Application number: 2023/92023	
What is the application for?:	Change of use from general industry B2 to storage and distribution B8
Address of the site or building:	Z A Enterprises Ltd, 4, Marsh Gardens, Honley, Holmfirth, HD9 6AP
Postcode:

Description
SITE PLAN

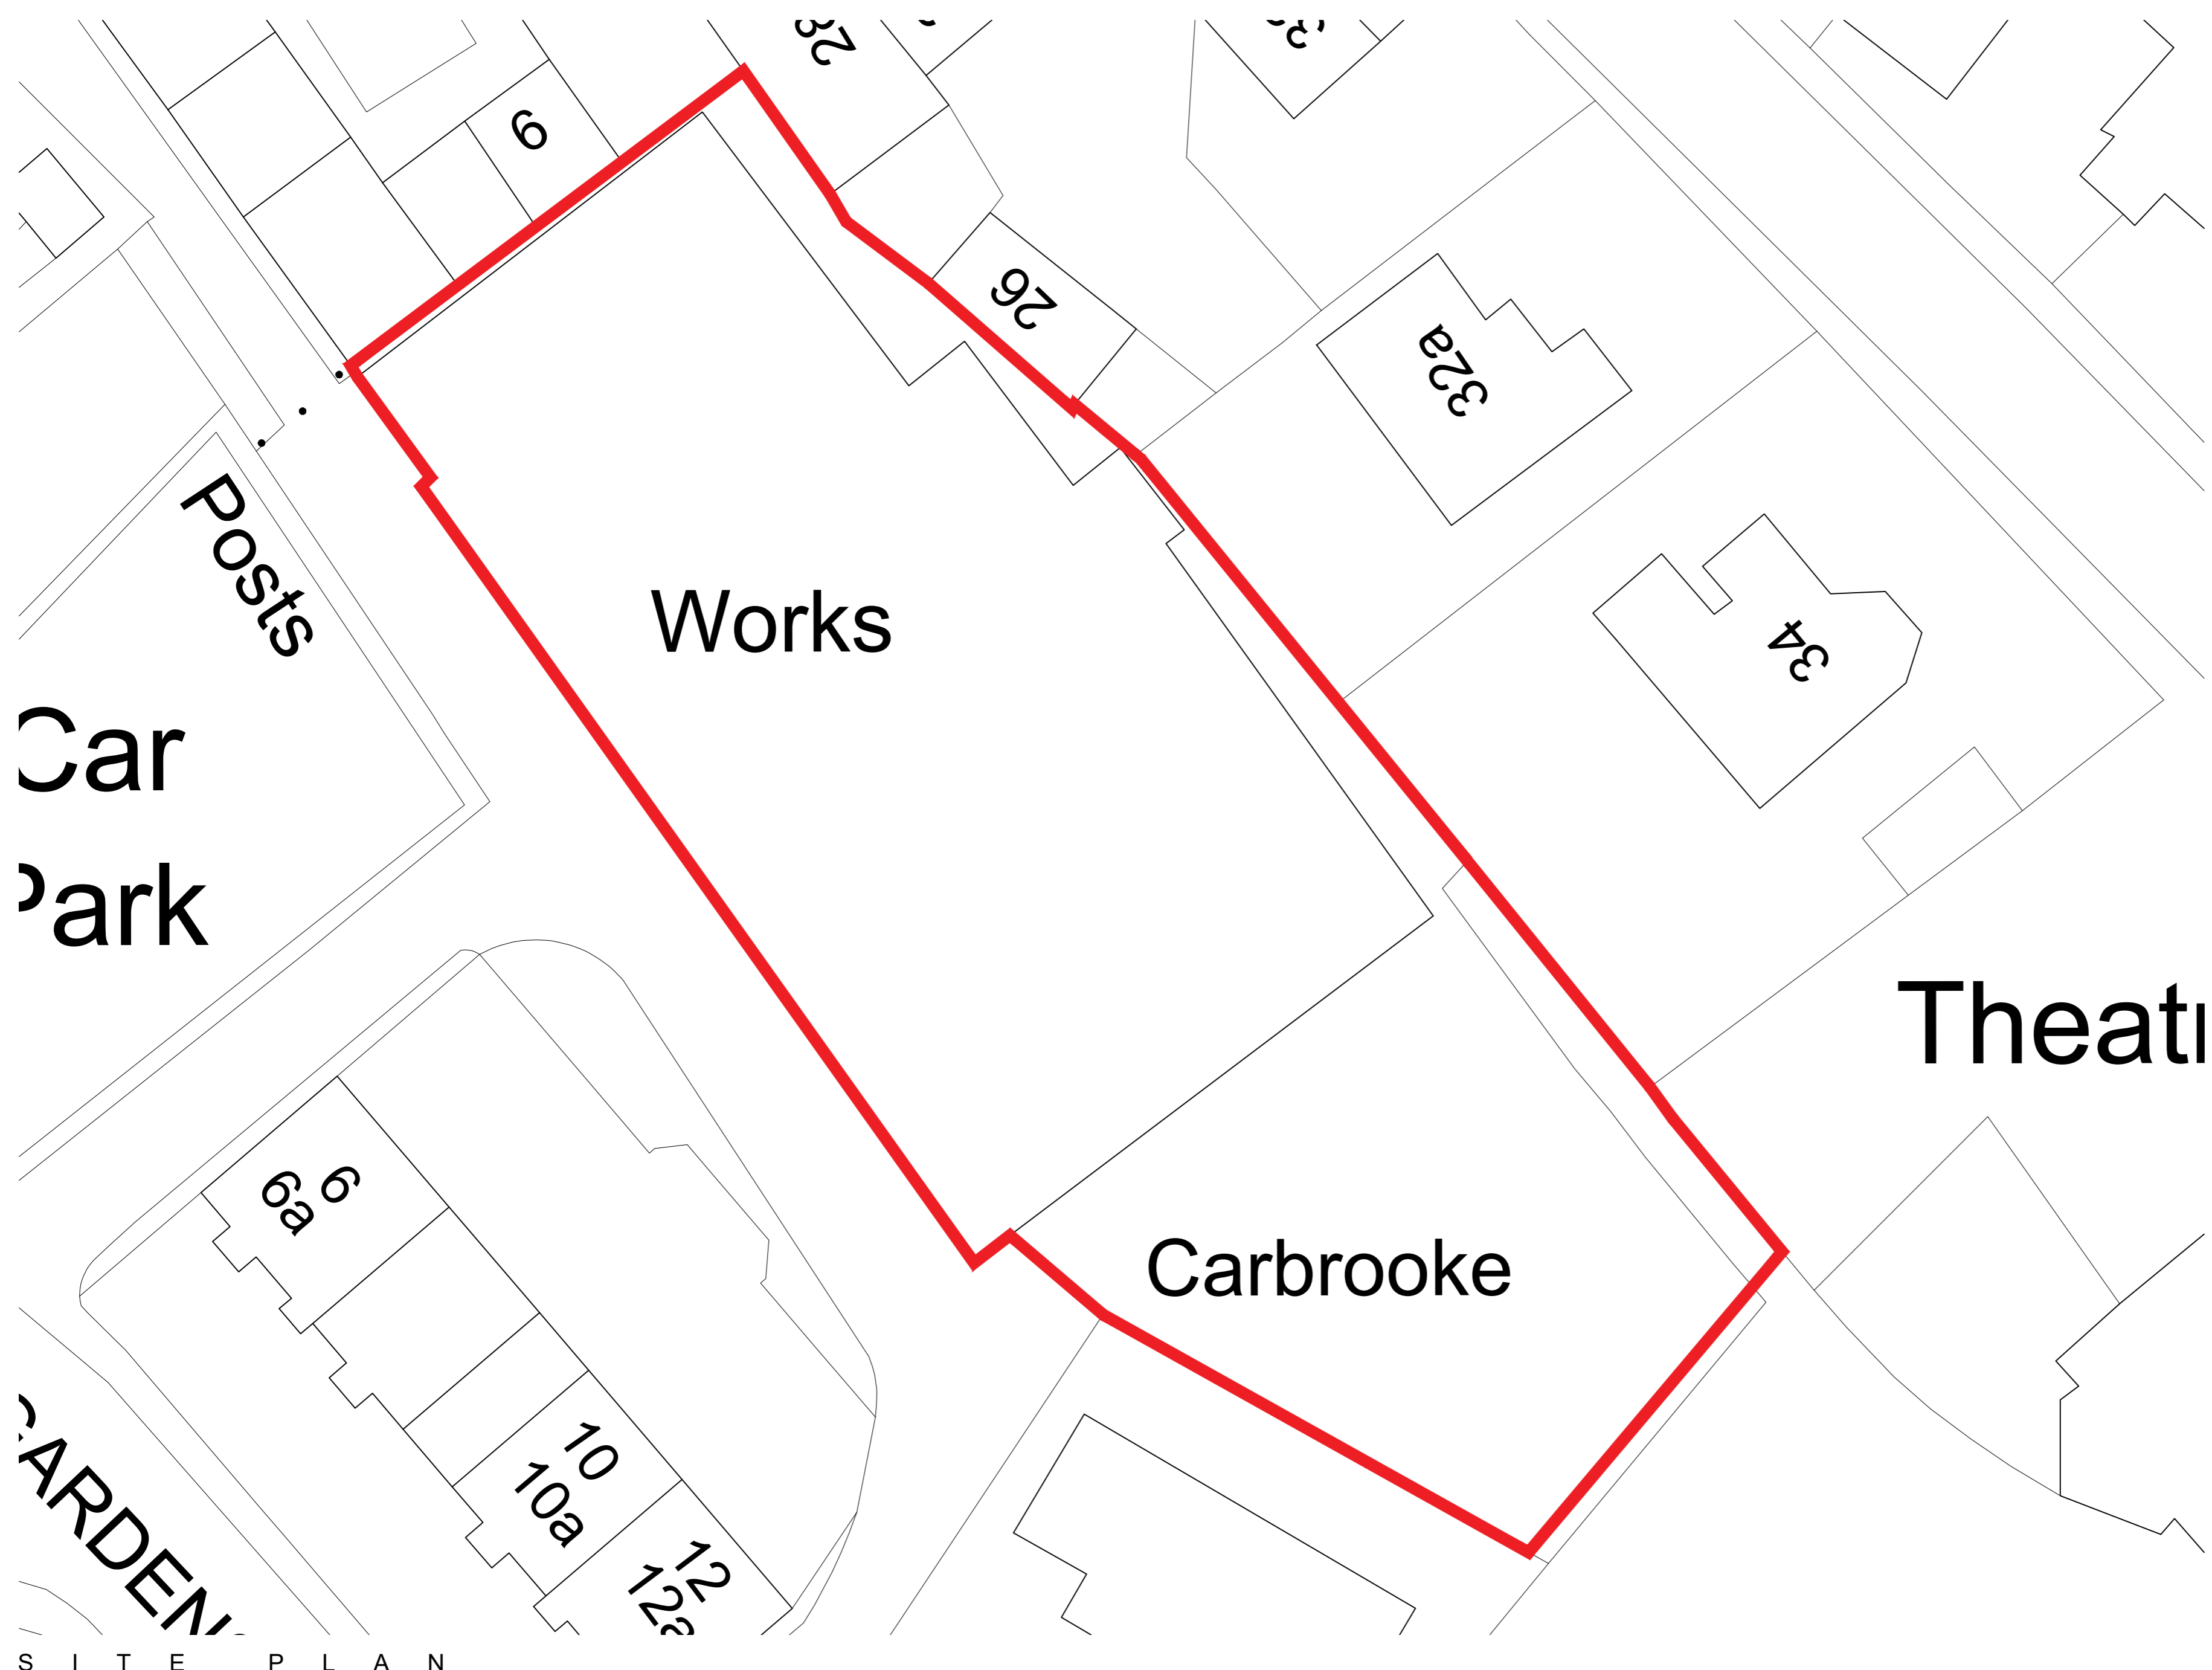
Type of comment: An objection	
Do you wish your comments to be published on the website anonymously?	<input type="checkbox"/> Yes
I live adjacent to car park entrance where it is suggested lorries turn round. Having had my fence twice hit by vehicles I don't think the proposals would work. As far as I am aware the area in front of the works and by my fence is public footpath and not a road.
